**WELWYN HATFIELD BOROUGH COUNCIL
EXECUTIVE DIRECTOR - PLANNING, PUBLIC PROTECTION AND GOVERNANCE**

Application No: 6/2017/0056/HOUSE
Location: 9 West View Hatfield AL10 0PJ
Proposal: Erection of single storey rear and part side extension
Officer: Ms L Hale

Recommendation: Granted

DRAWING
Proposed Ground Floor
and Roof Plans

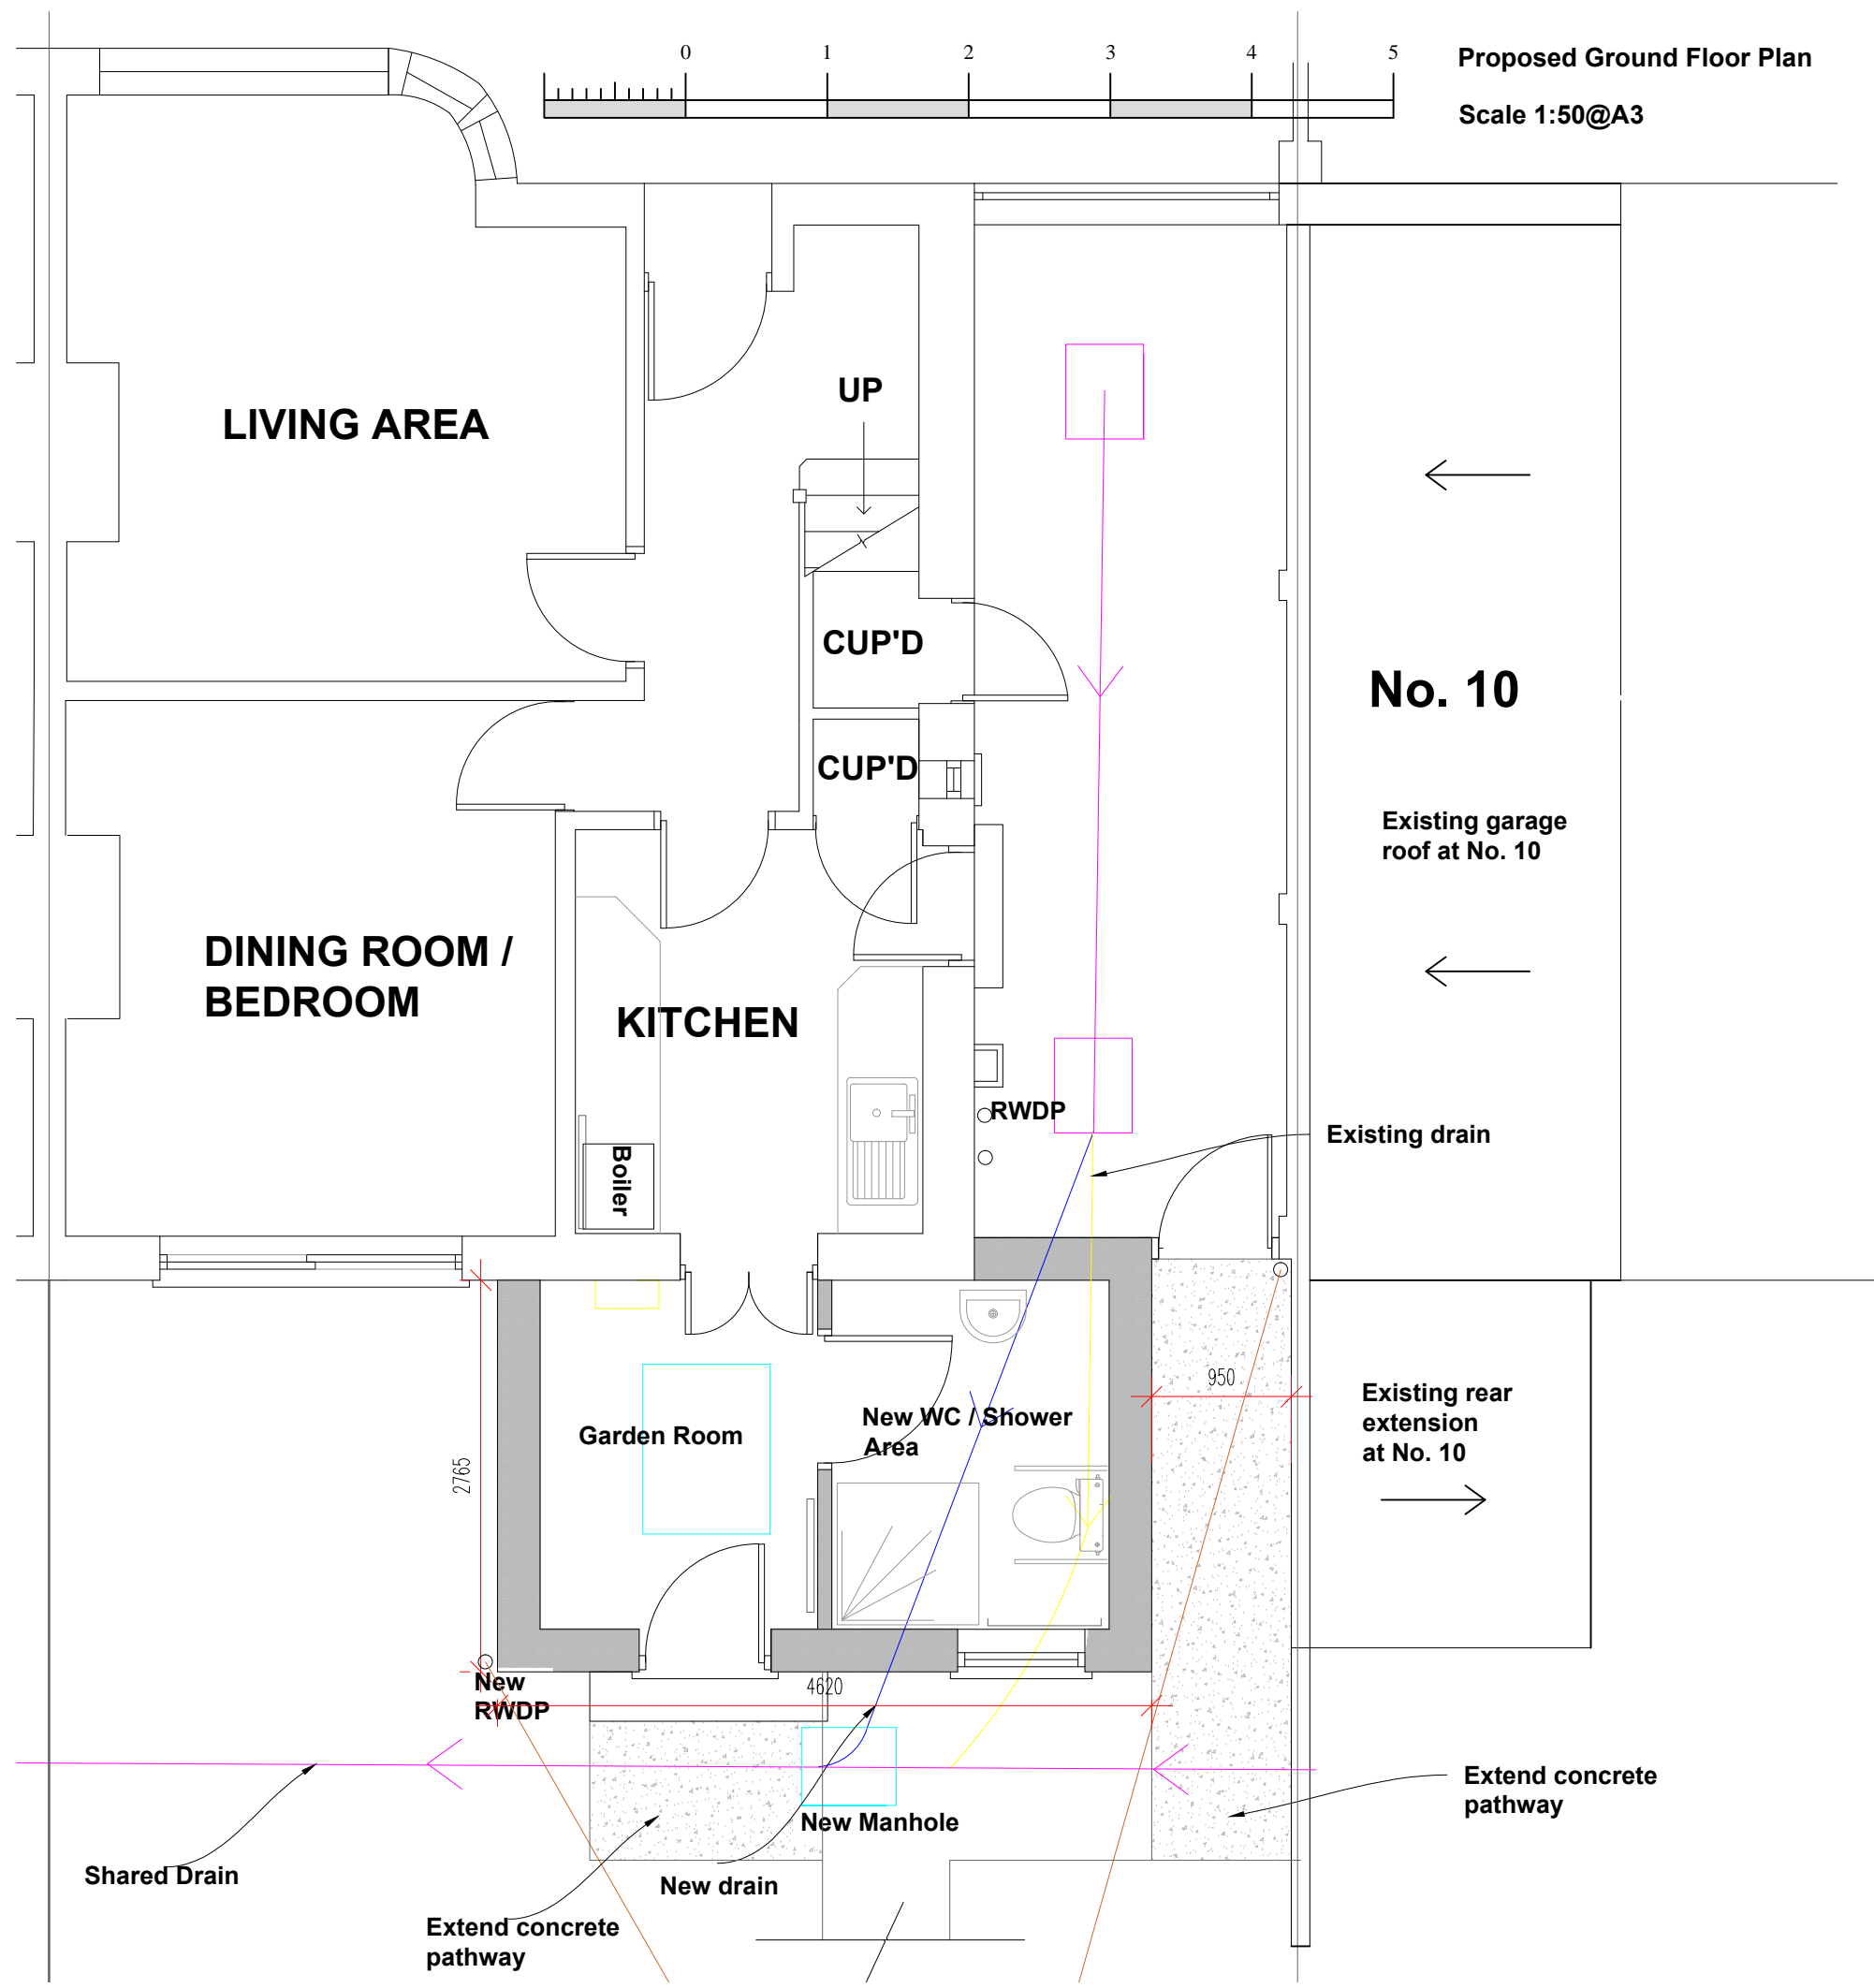
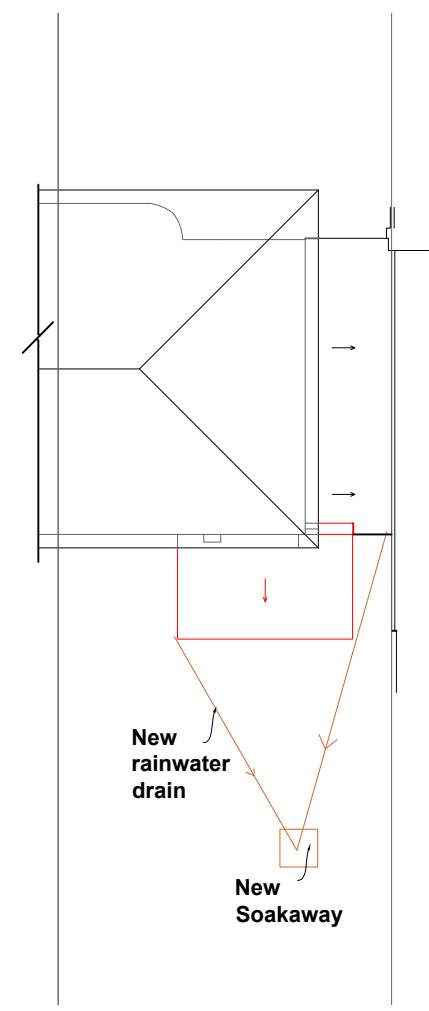
The application seeks planning permission for the erection of a single storey rear and part side extension. The extension would measure approximately 4.5 metres wide by 2.7 metres deep with a maximum height of 3.6 metres. The extension is considered of modest size and would appear subordinate in scale to the existing dwelling. Part of the extension would be visible from the streetscene, above the existing garage but this is not considered to be harmful to the character and appearance of the streetscene.

The neighbouring properties are No. 8 and 10 West View. With regard to No.8 West View, this property sits to the south of the host site and is attached. The proposed single storey extension would be set in from the shared boundary by approximately 3.1 metres and is not considered to result in a detrimental loss of sunlight or appear overbearing. In addition, no side windows are proposed and so the privacy would be retained.

With regards to No.10 West View, this property sits to the north of the host dwelling. The proposed extension would be set in by approximately 1 metre from the boundary. Given the proposed size of the extension, as well as the single storey side extension along the shared boundary at No.10, it is not considered that there would be a detrimental loss of light or appear unduly dominant. No side windows are proposed and so there would be no increased overlooking or loss of privacy.

DRAWING
Proposed Elevations
and First Floor Plan

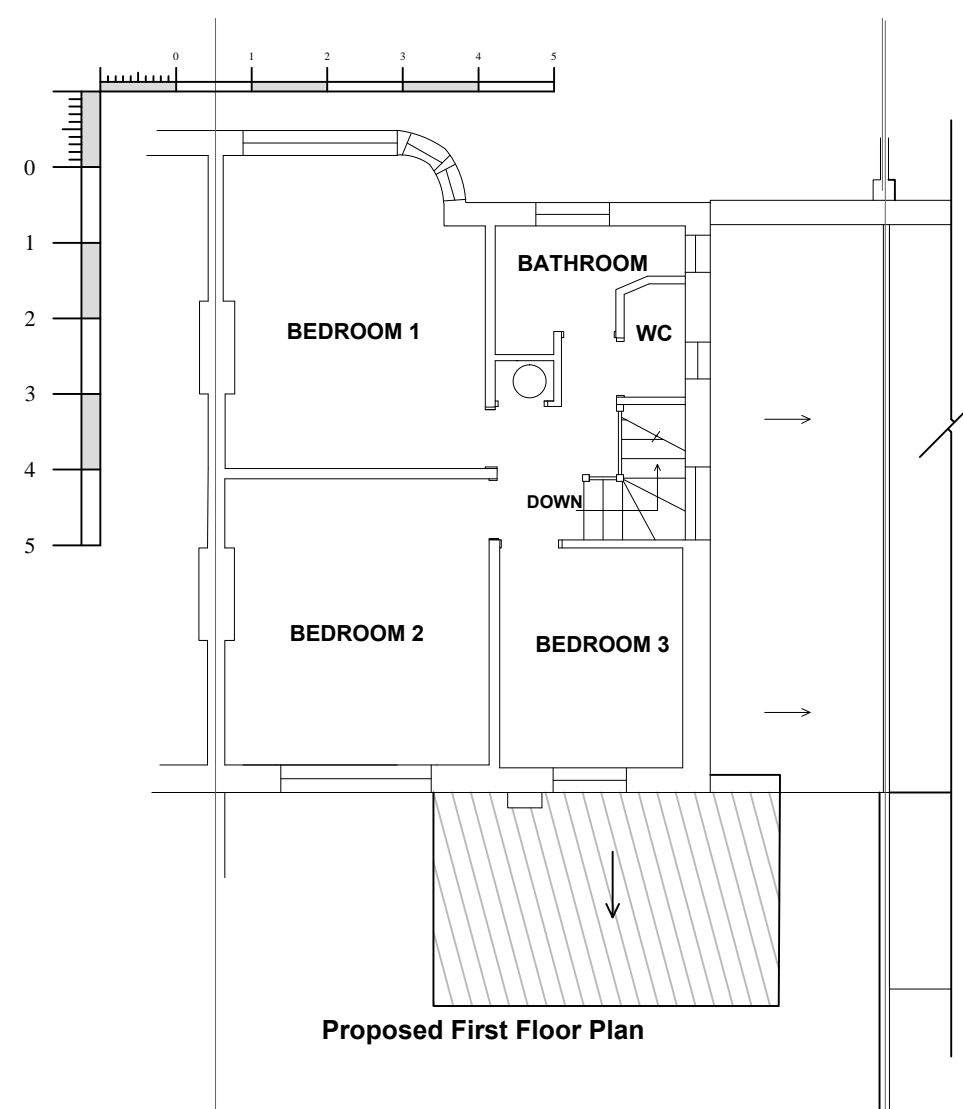
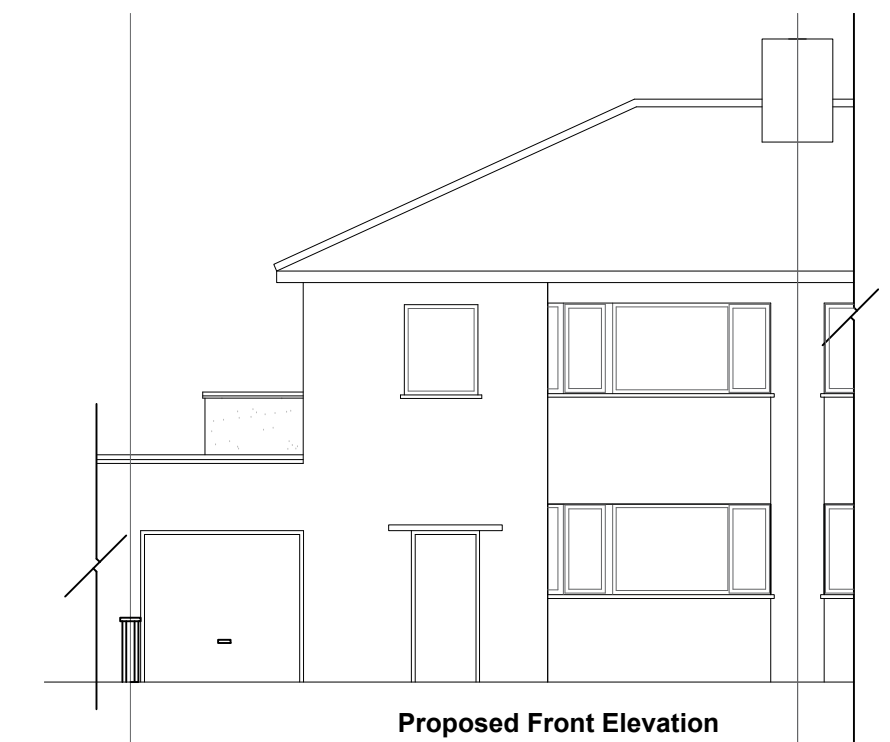
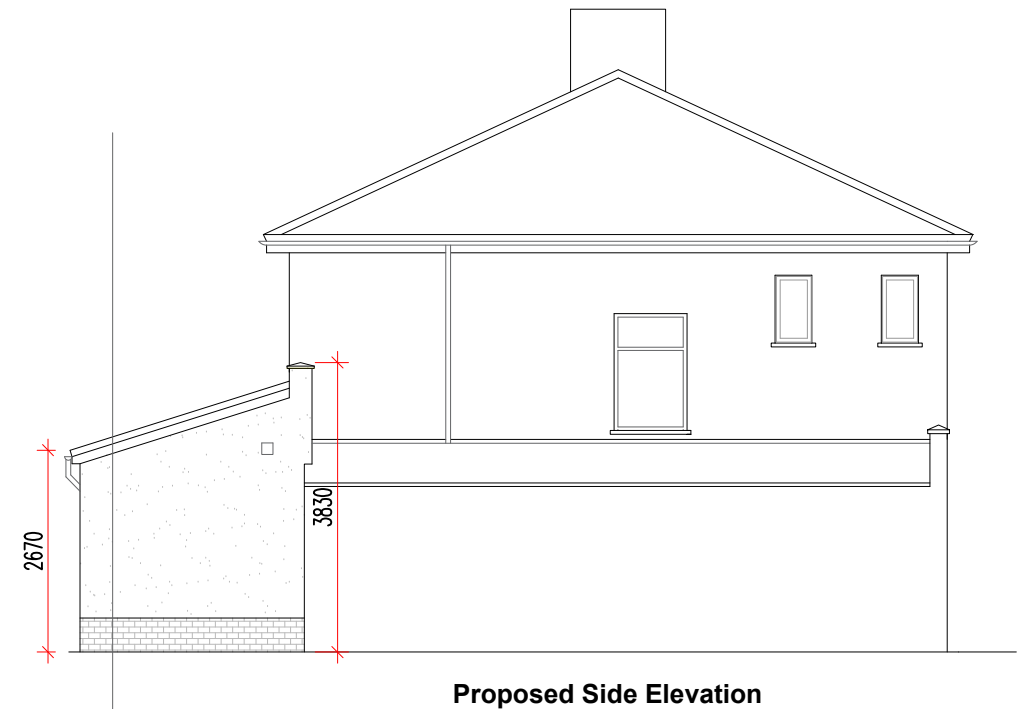
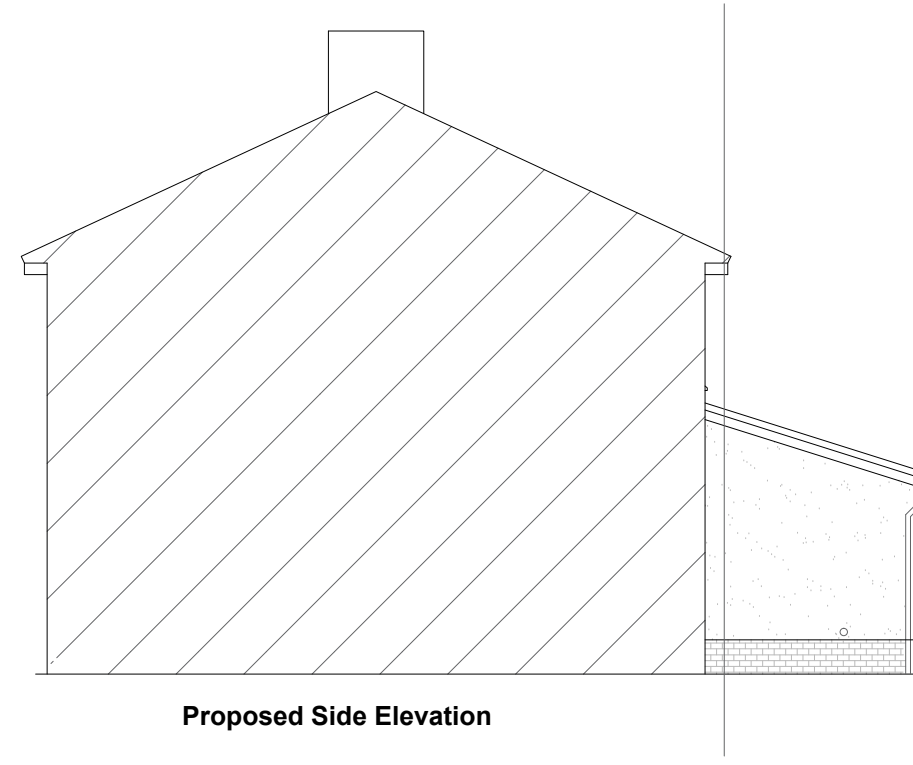
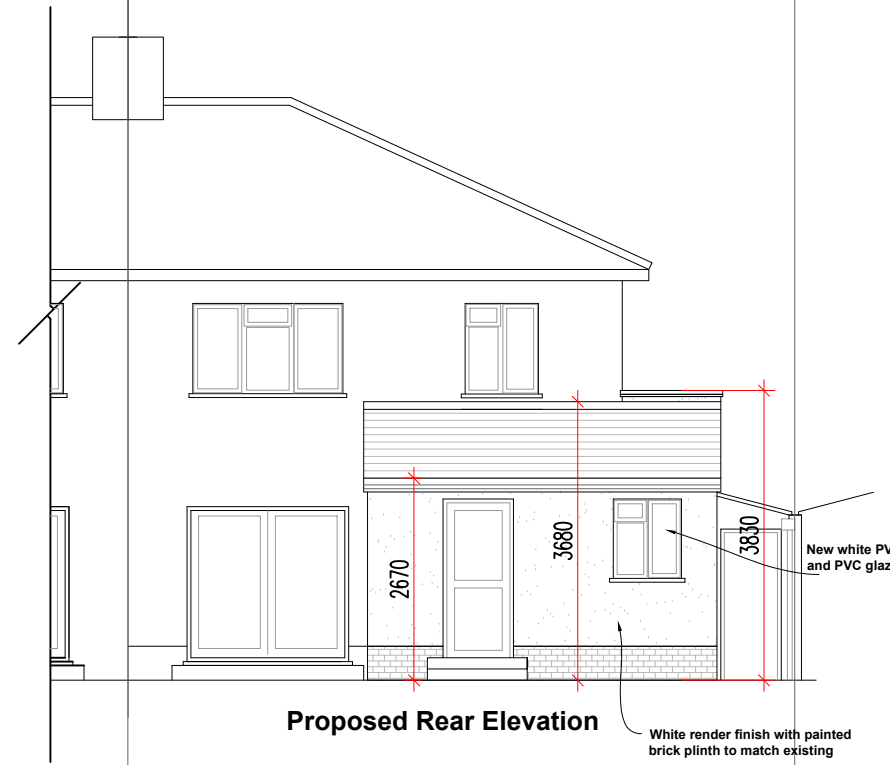
The design of a sloping roof with matching tiles to the existing roof is considered to respect the character and appearance of the dwelling. The fenestration detailing is also considered to reflect those in the existing dwelling and is acceptable.
